Recommendation Report for Planning Permission for Works or Extension to a Dwelling

REF NO: FG/210/21/HH

LOCATION: 23 Little Paddocks
Ferring
BN12 5NJ

PROPOSAL: Front balcony/inset dormer and 1st floor rear extension.

Drawing no 11917-1f

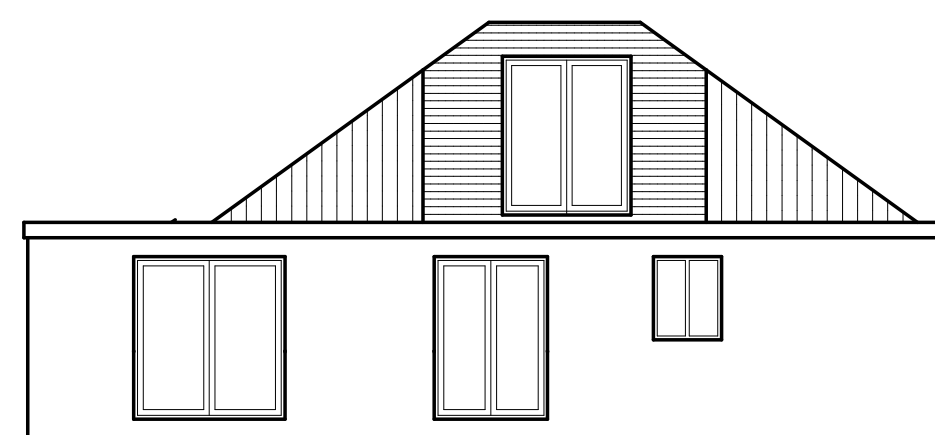
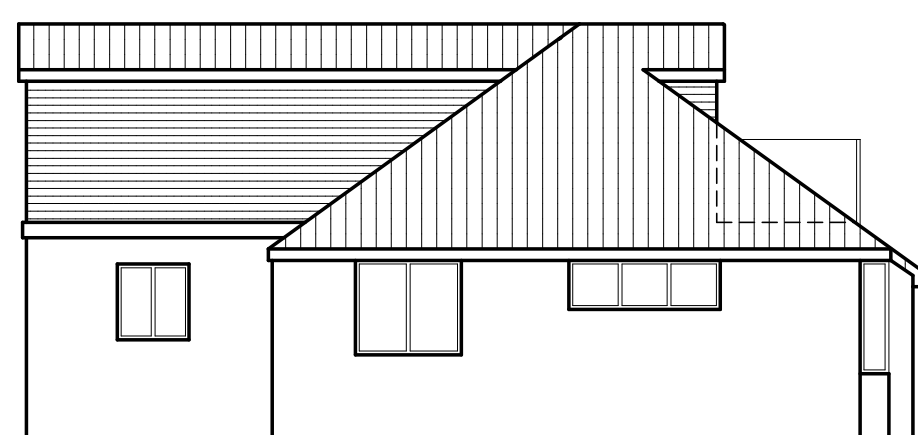
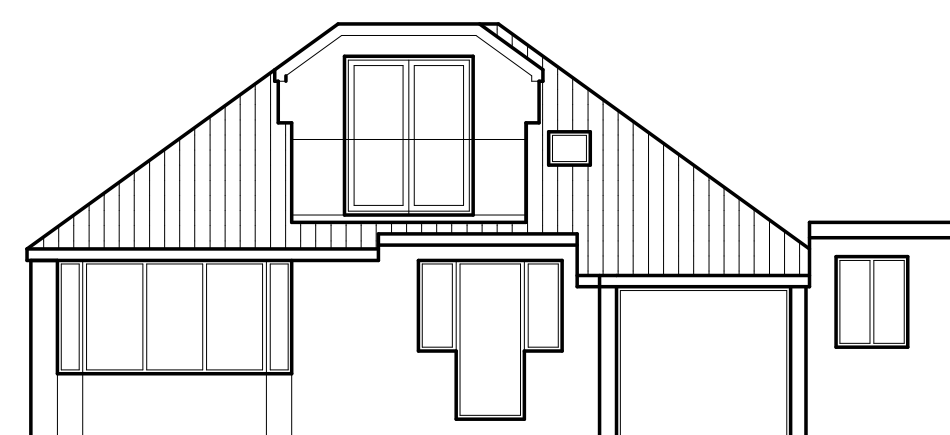
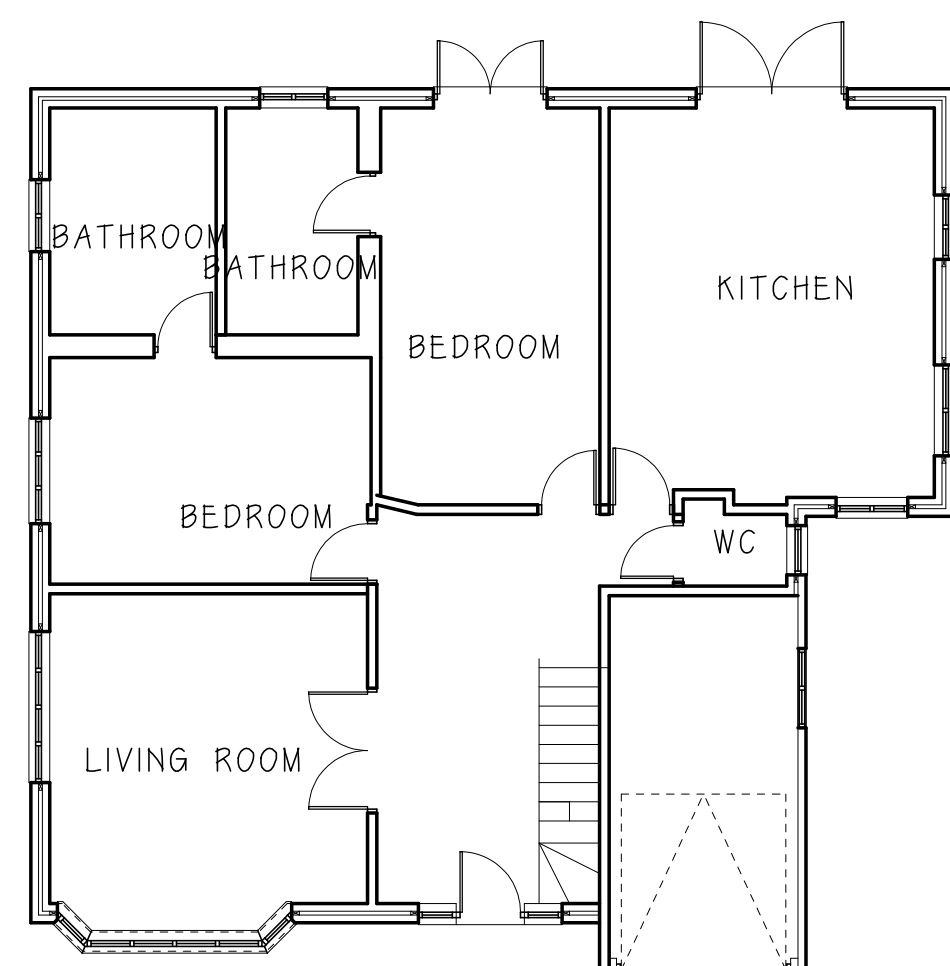
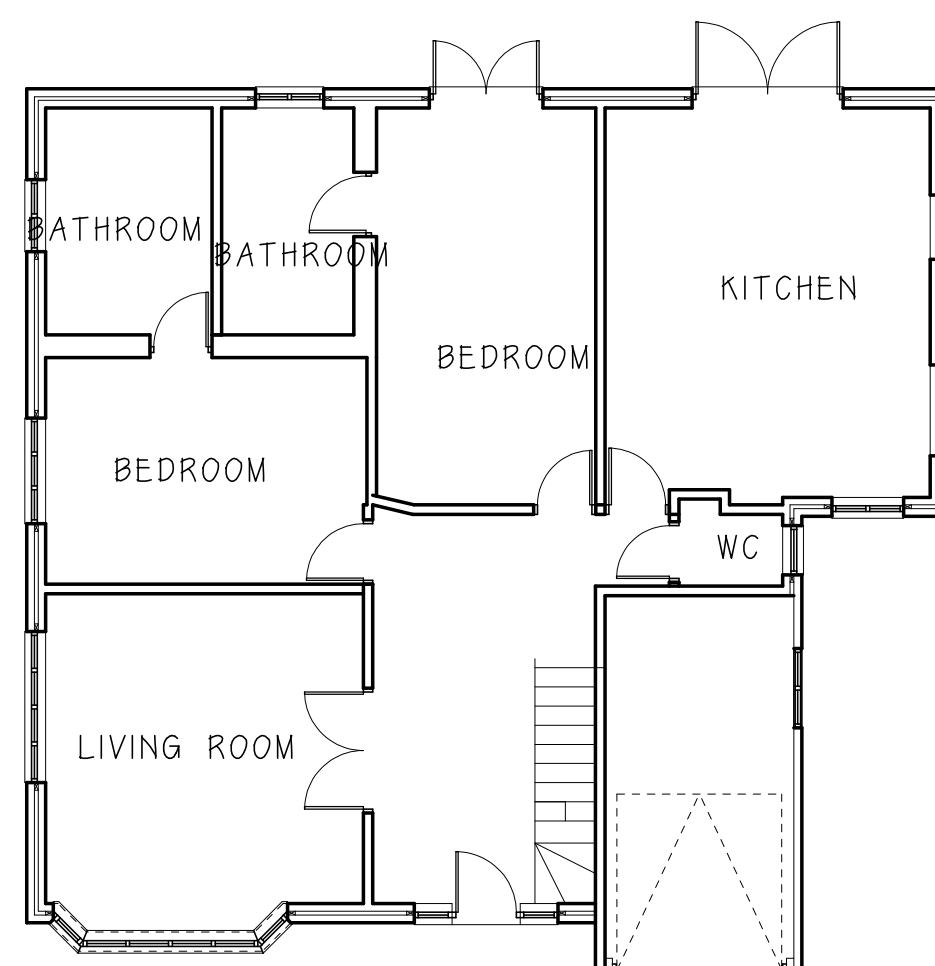
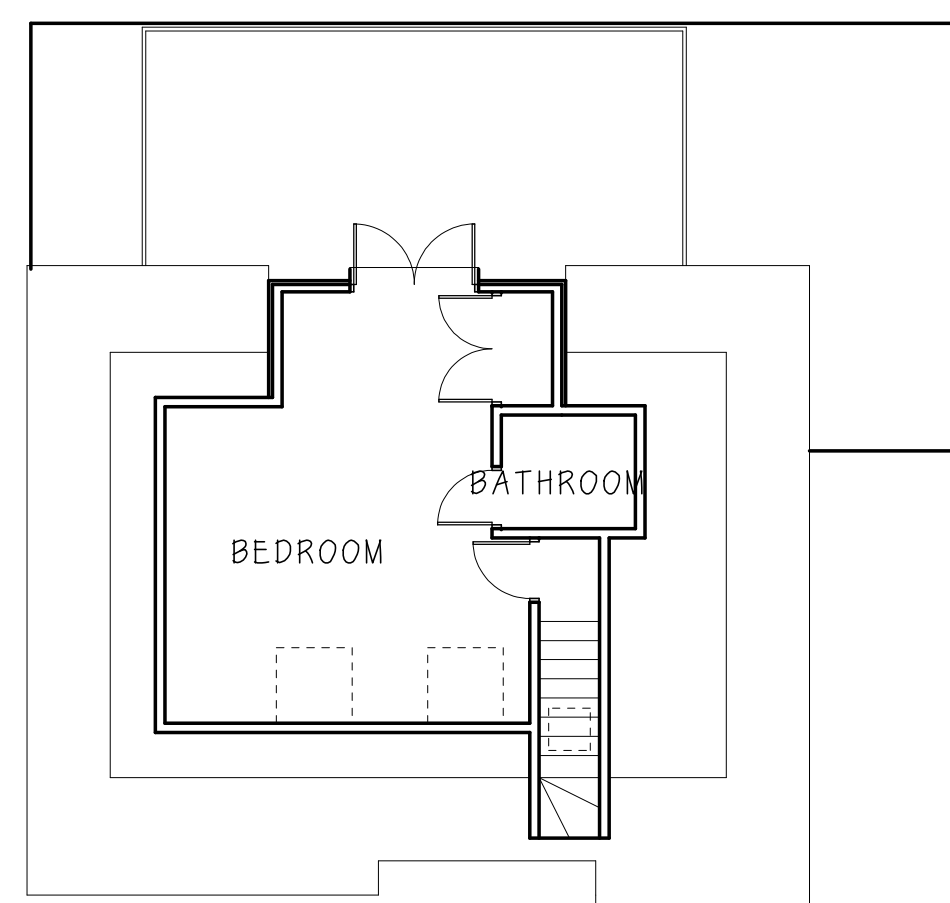
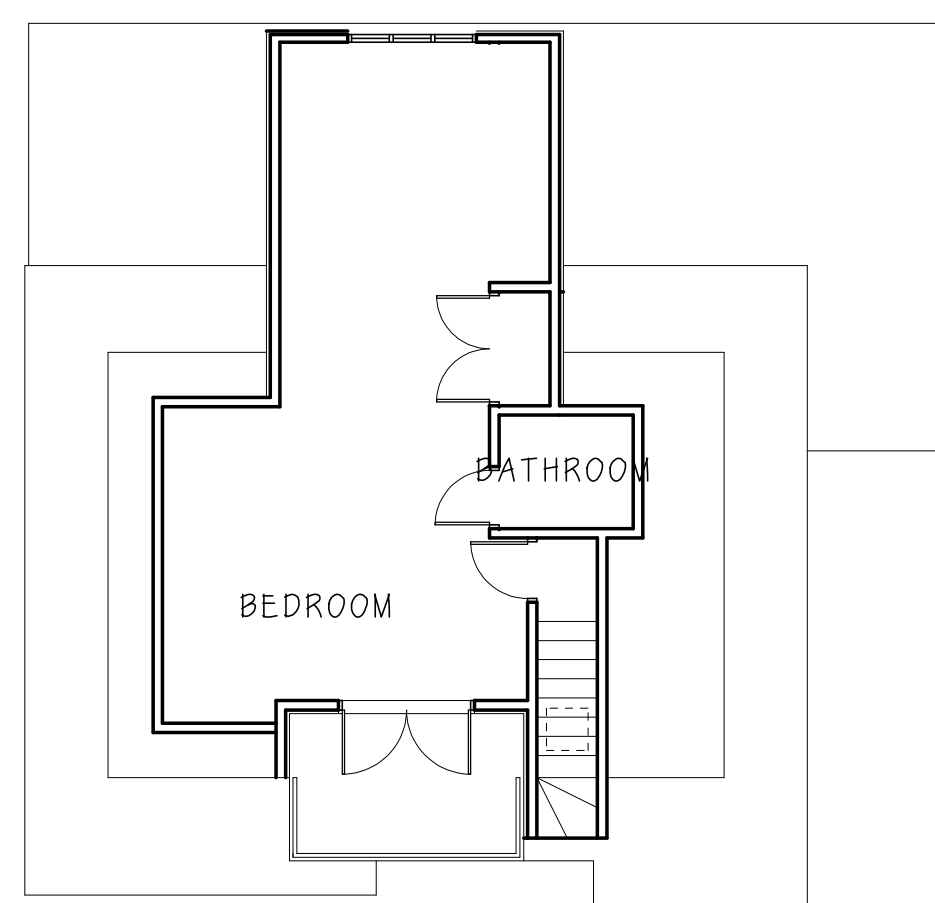
The proposal includes the erection of a central, front inset dormer that is approx. 3.4m in width and extends approx. 1.8m to the front of the dwelling with an associated front facing balcony. The front facing balcony is also approx. 3.4m in width but projects approx. 1.9m to the front of the property but remaining inset from the front principal elevation.

The proposal also includes a rear second storey extension that is approx. 3.8m in width and projects approx. 3.3m to the rear of the property off of the existing loft conversion. The second storey rear projection extends out on top of the existing single storey rear extension, ending in line with the rear elevation. This extension is central to the roof and as such is deemed appropriate sitting by Section M of the Arun Design Guide.

The proposal protrudes approx. 3.3m to the rear of the property. Due to its orientation the addition has the ability to overlook No. 45 Sea Lane Gardens. However there remains a back to back separation distance of approx 18m which falls below the guide set out in Section G of the Arun Design Guide. The addition allows for viewpoints into other rear neighbour dwellings, but these impacts are minimal due to vast rear garden private amenity space or minimal sightline intersection. Nevertheless there is potential for an adverse impact on neighbouring amenity (in particular No.45) by way of overlooking, therefore a condition has been attached that requires the second storey (first floor) rear window of the proposal to be obscured glazed in order to minimise these impacts.

The proposal also includes a front facing balcony. This balcony provides a front facing viewpoint onto the street. The street is not deemed private amenity space and as such the viewpoint provided onto this area is deemed acceptable. However, the balcony is set forward from the front facing dormer and as such, allows for side facing viewpoints. As this is a corner property, the side facing viewpoints from this dormer predominantly overlook the front of the east and west neighbour dwellings (22 and 24 Little Paddocks). A condition has therefore been attached regarding the obscuring of the sides of this front facing balcony, in order to minimise overlooking onto these neighbouring properties.

- 3 The North-West and South-East elevations of the proposed front facing balcony hereby approved shall at all times, be screened with an obscured barrier to a minimum height of 1.7m from the balconies finished floor level. The screening shall be retained in perpetuity.

- 4 The rear facing window incorporated into the second storey rear extension (first floor) hereby approved shall at all times, be obscure glazed up to a minimum height of 1.7m from finished floor level. The screening shall be retained in perpetuity.
